## Response to Submissions Report

‘Pathways Leura Village Seniors Housing’  
(SSD-80068720)

203-223 Leura Mall, Leura

5 February 2026

DRAWING TITLE:  
 DRIVEWAY SECTIONS

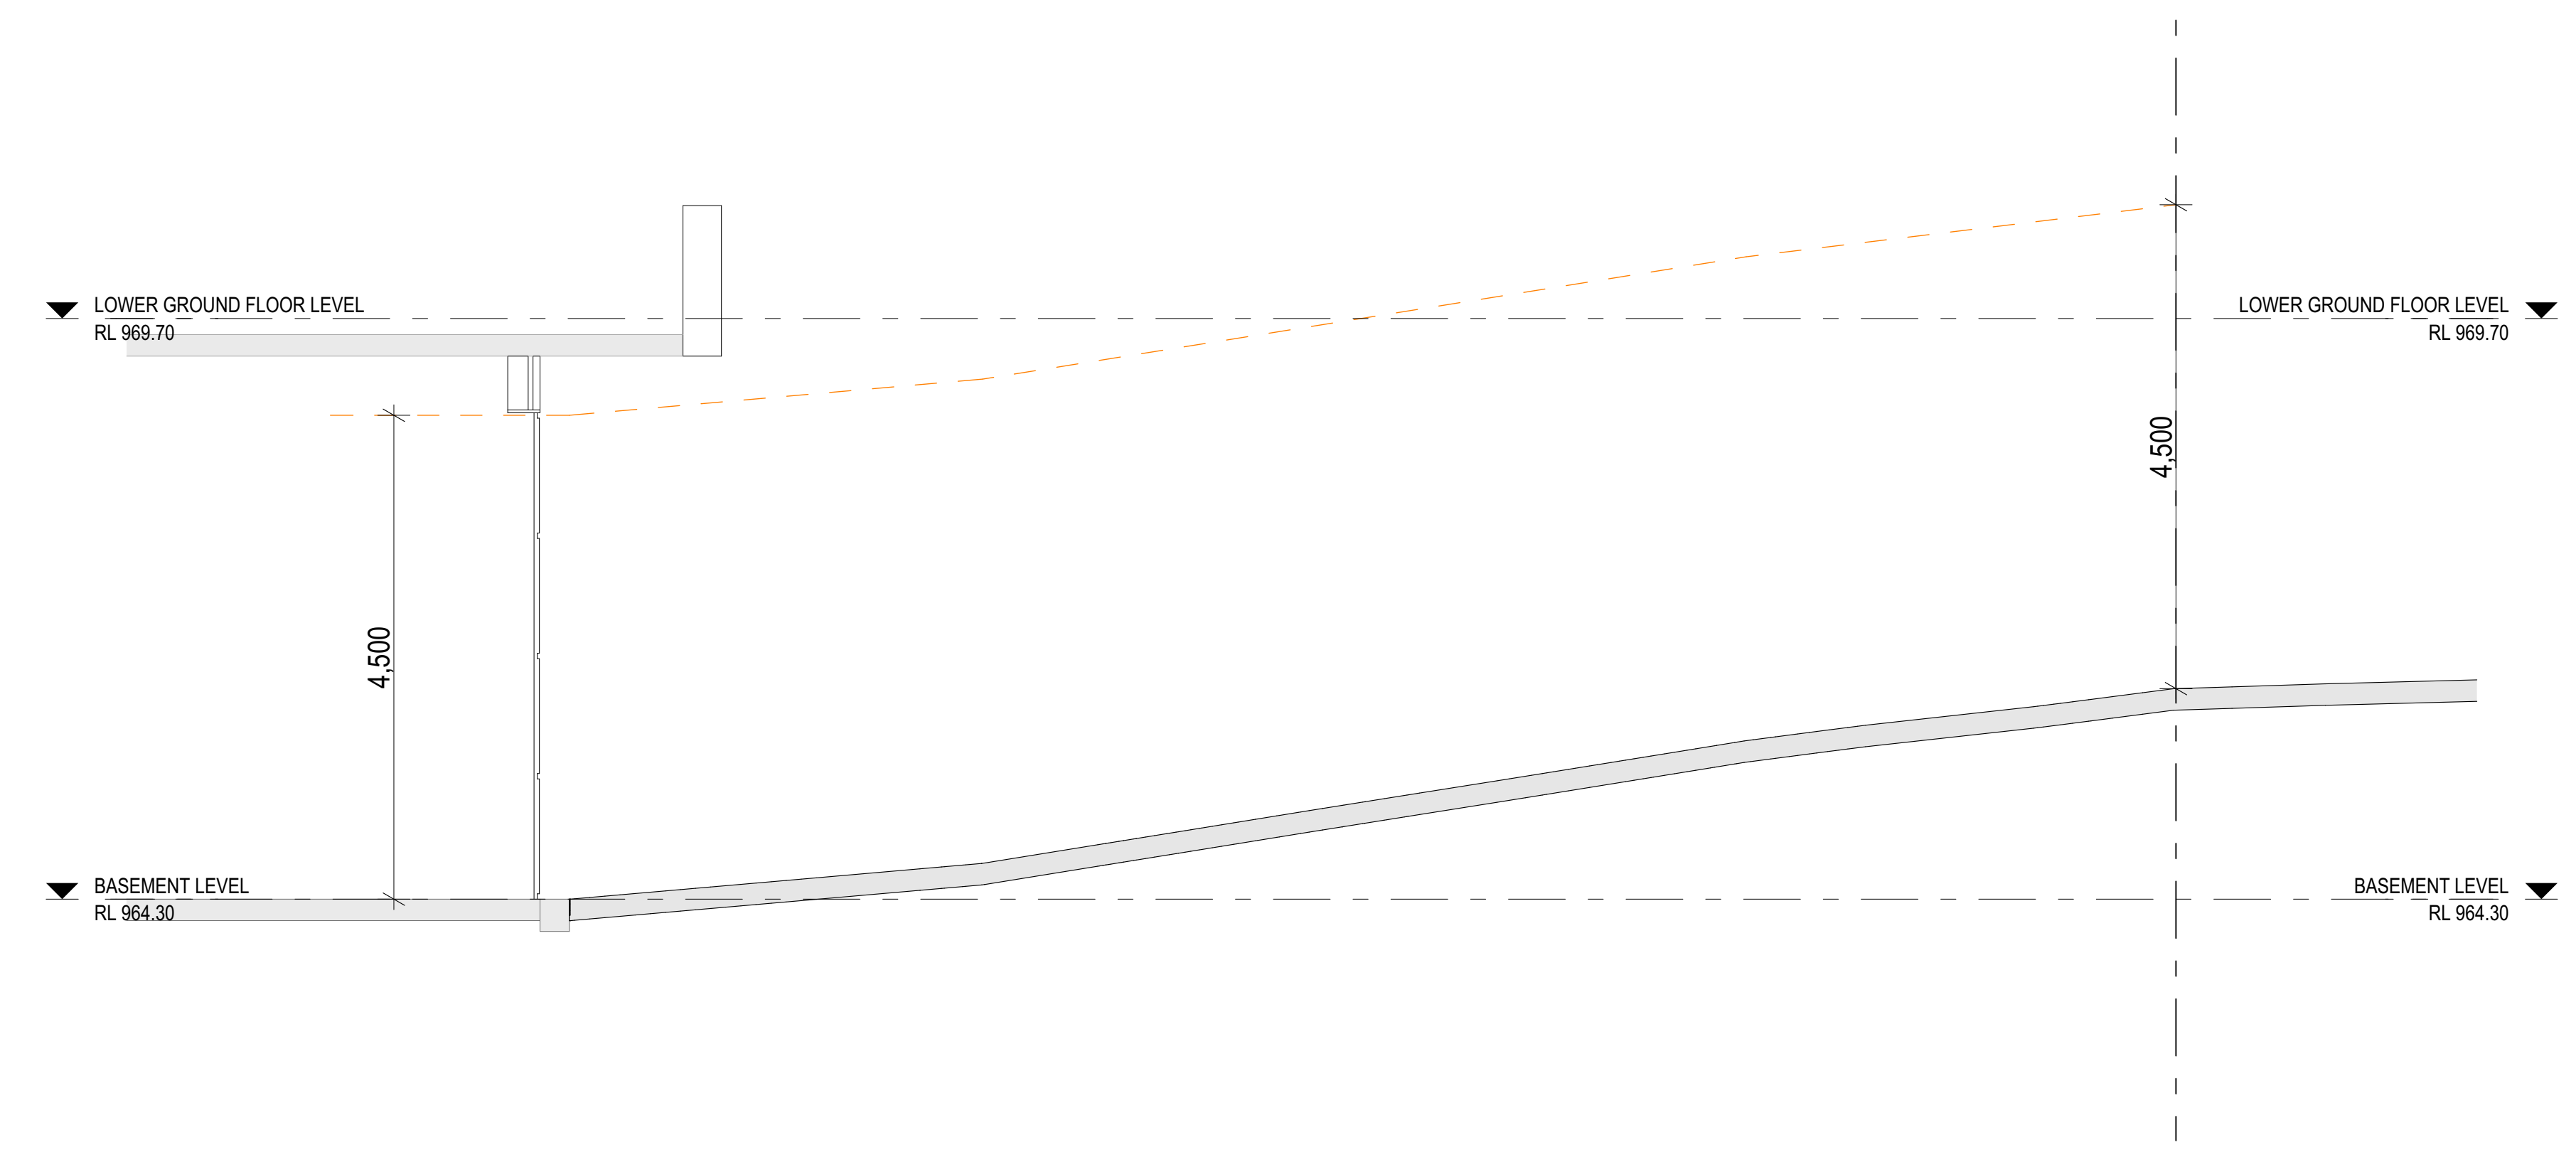
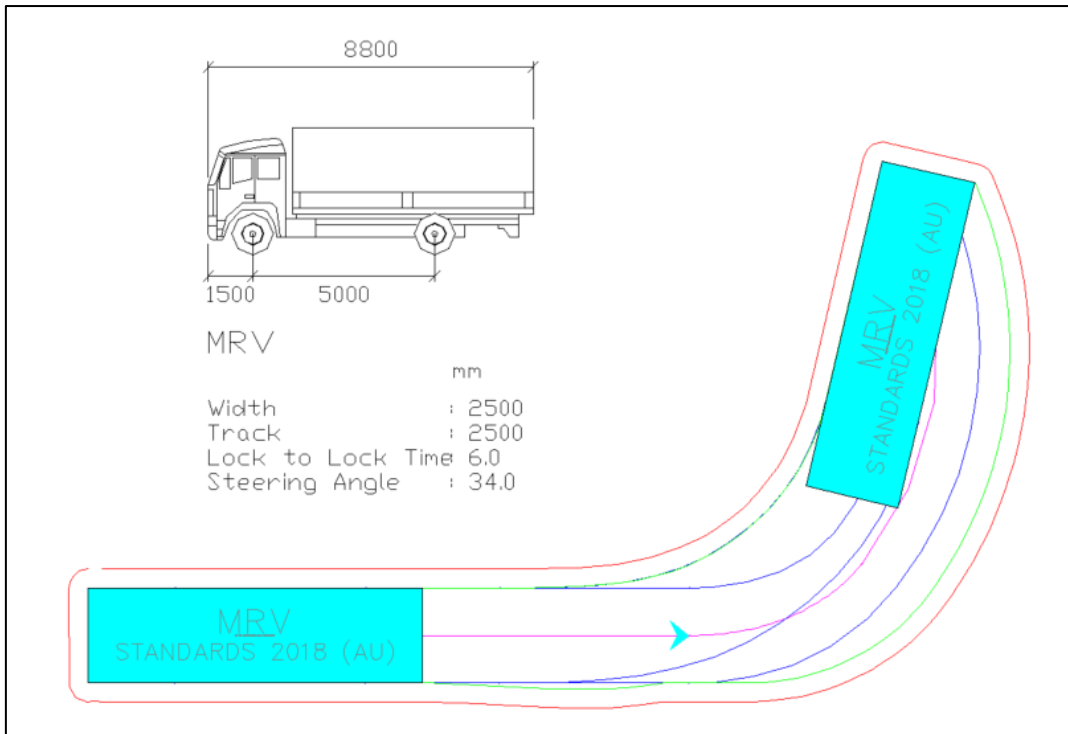
- Traffic and car parking – Additional justification is sought as to how it has been determined that no traffic will travel south from the site. Further, DPHI requested a section plan showing the basement driveway achieves the required head height clearance of the largest vehicle proposed to enter the basement.

DPHI Raised Issue	Response	Relevant report(s)
<p>heritage significance of the site.</p>		
<p><b>5. Traffic and Car Parking</b></p> <p>a. Provide additional justification on how it has been determined that no traffic will travel south from the site. It is noted that the intersection of Wascoe Street / Craigend Street has not been assessed at all. Further, no post development intersection assessment has been provided as it was considered that the Leura Mall / Craigend Street intersection will carry no traffic from the development.</p>	<p>As noted in the supplementary traffic and parking advice prepared by McLaren (Appendix 11), the site is located such that there is only a very small catchment of residential area that is located to the south of the site. Additionally, there is no primary attractors (supermarkets, local stores, small suburban shopping centres) located to the south of the site and the nearest highway connection to the site is located to the north as shown in the figure below. Therefore, for a person to leave the site and travel south they would need to be living in the small catchment of houses to the south.</p> <p>Furthermore, Megalong Street is the major road connection which supports greater traffic volume and hence adding all of the proposed traffic through this intersection results in a robust and conservative analysis of the surrounding traffic environment.</p>  <p><b>Figure 6: Residential area south of the subject site (Source: McLaren)</b></p> <p>In any case, and to avoid doubt, a sensitivity assessment of the intersection of Wascoe Street / Craigend Street has been undertaken by interpolating the traffic volumes from the nearby intersections and applying 100% of the proposed development traffic through the intersection.</p>	<ul style="list-style-type: none"> <li>Supplementary traffic and parking advice (Appendix 11)</li> </ul>
